CITY OF ALBUQUERQUE

December 18, 2017

**Re: Family Dollar-1400 Gibson SE
Erosion and Sediment Control Plan
Engineer's Stamp Date 12-13-17 (L15E049)**

FAMILY DOLLAR STORE			
EROSION & SEDIMENT CONTROL PLAN			
MARK GOODWIN & ASSOCIATES, P.A. CONSULTING ENGINEERS P.O. BOX 90606 ALBUQUERQUE, NEW MEXICO 87199 (505)828-2200, FAX (505)797-9539			
Designed: DMG	Drawn: DER	Checked: DMG	Sheet 1 of 1
Scale: 1" = 30'	Date: 11/10/17	Job: A16075

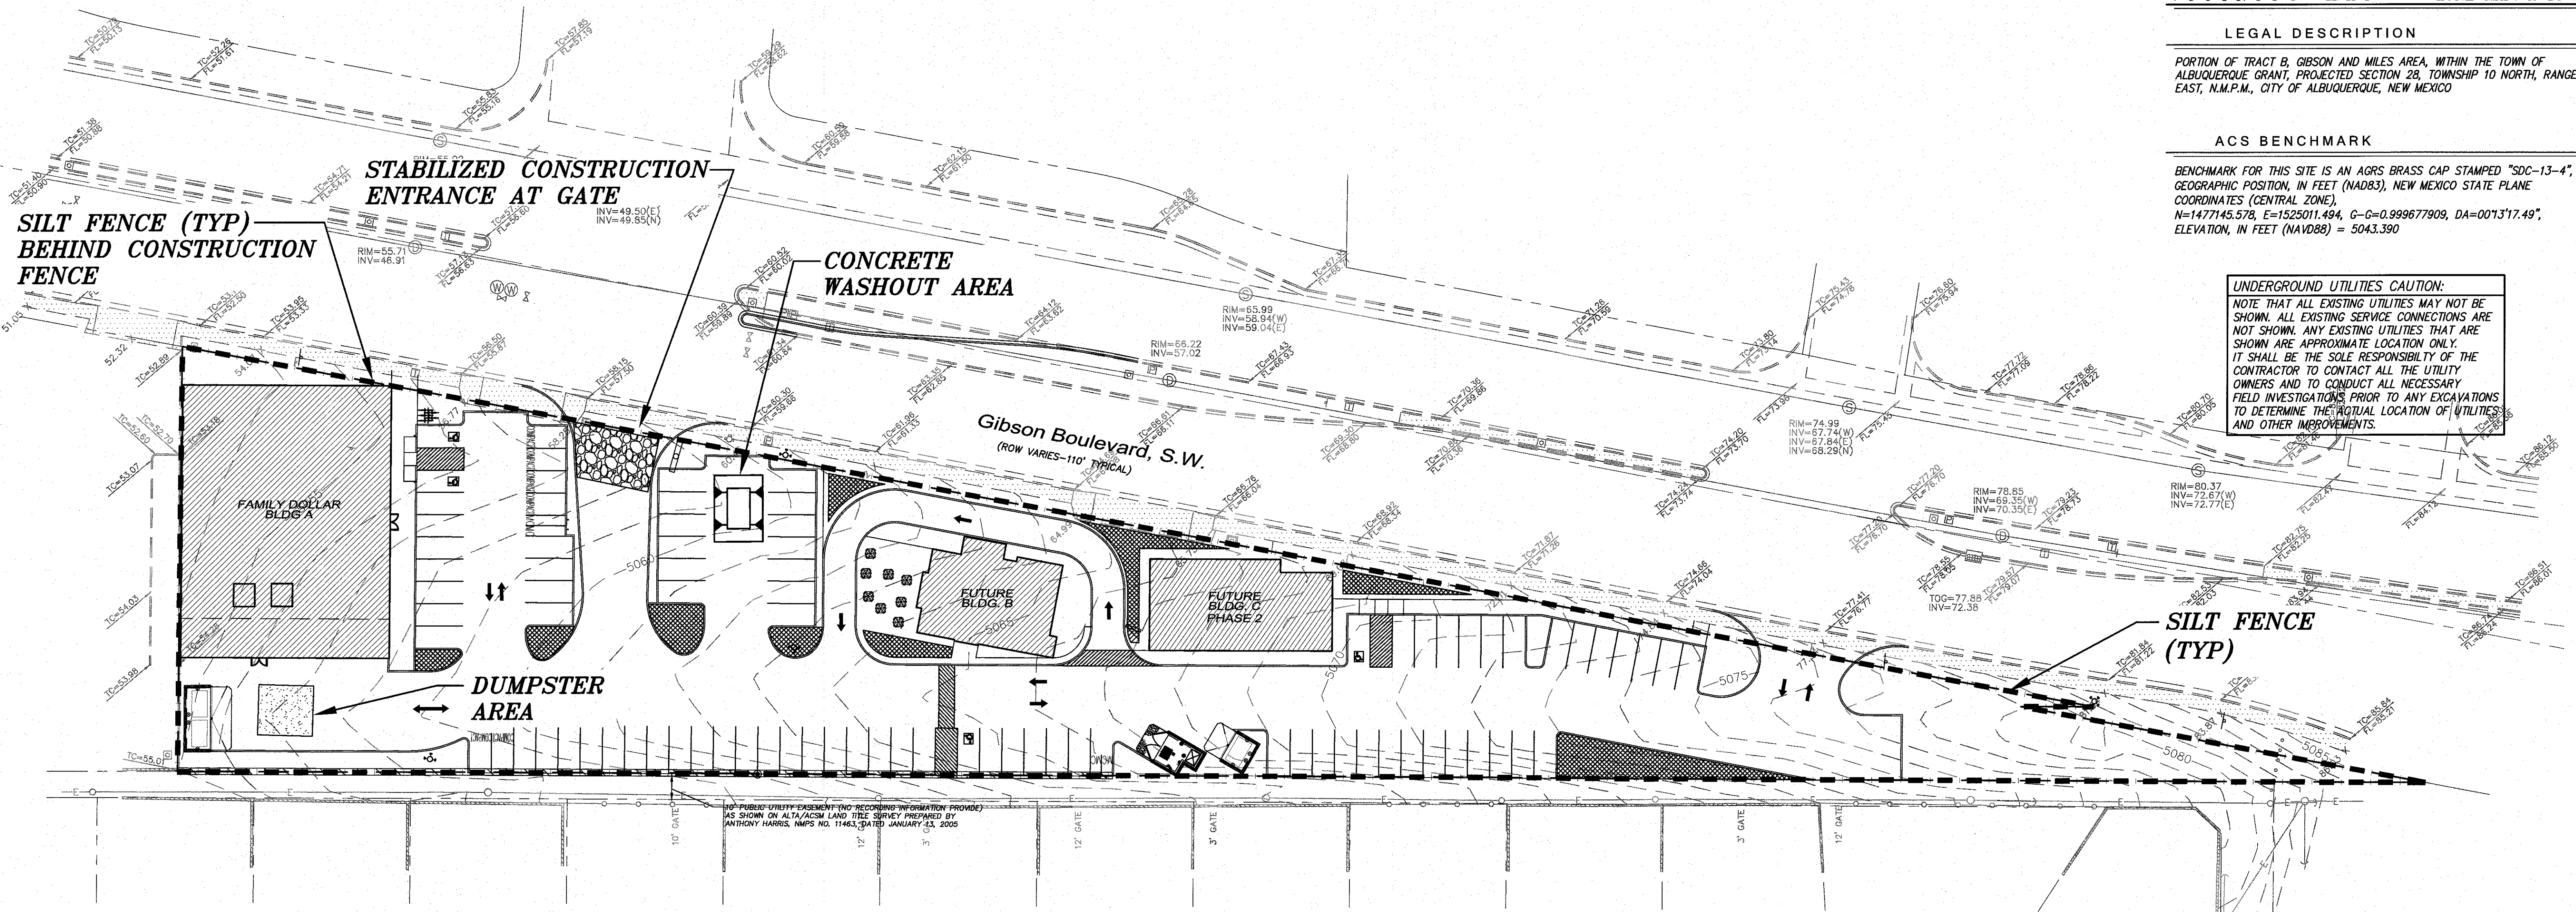
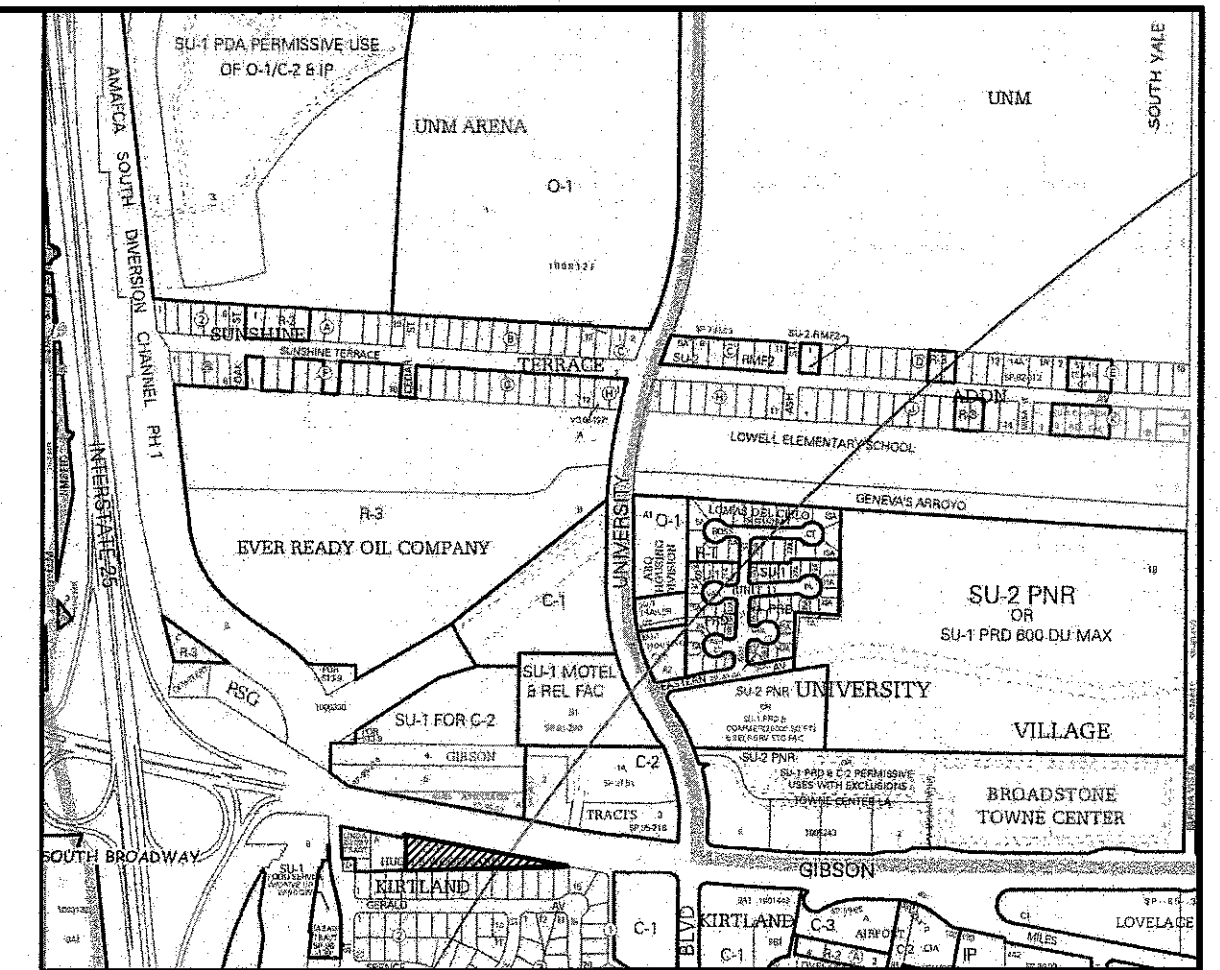
1. The plan did not include proposed grades or storm drain information. Basically, add erosion and sediment control BMPs to the grading and drainage plan that is submitted to Hydrology.

Having the proposed grades and drainage infrastructure on the plan is necessary information for the site inspection and for the review of the plan.

2. Include inlet protection for the proposed inlet shown on the grading plan.

3. If a BMP(s) was added for the storm drain and possibly other work in the Gibson ROW, the plan could be submitted for Work Order approval.
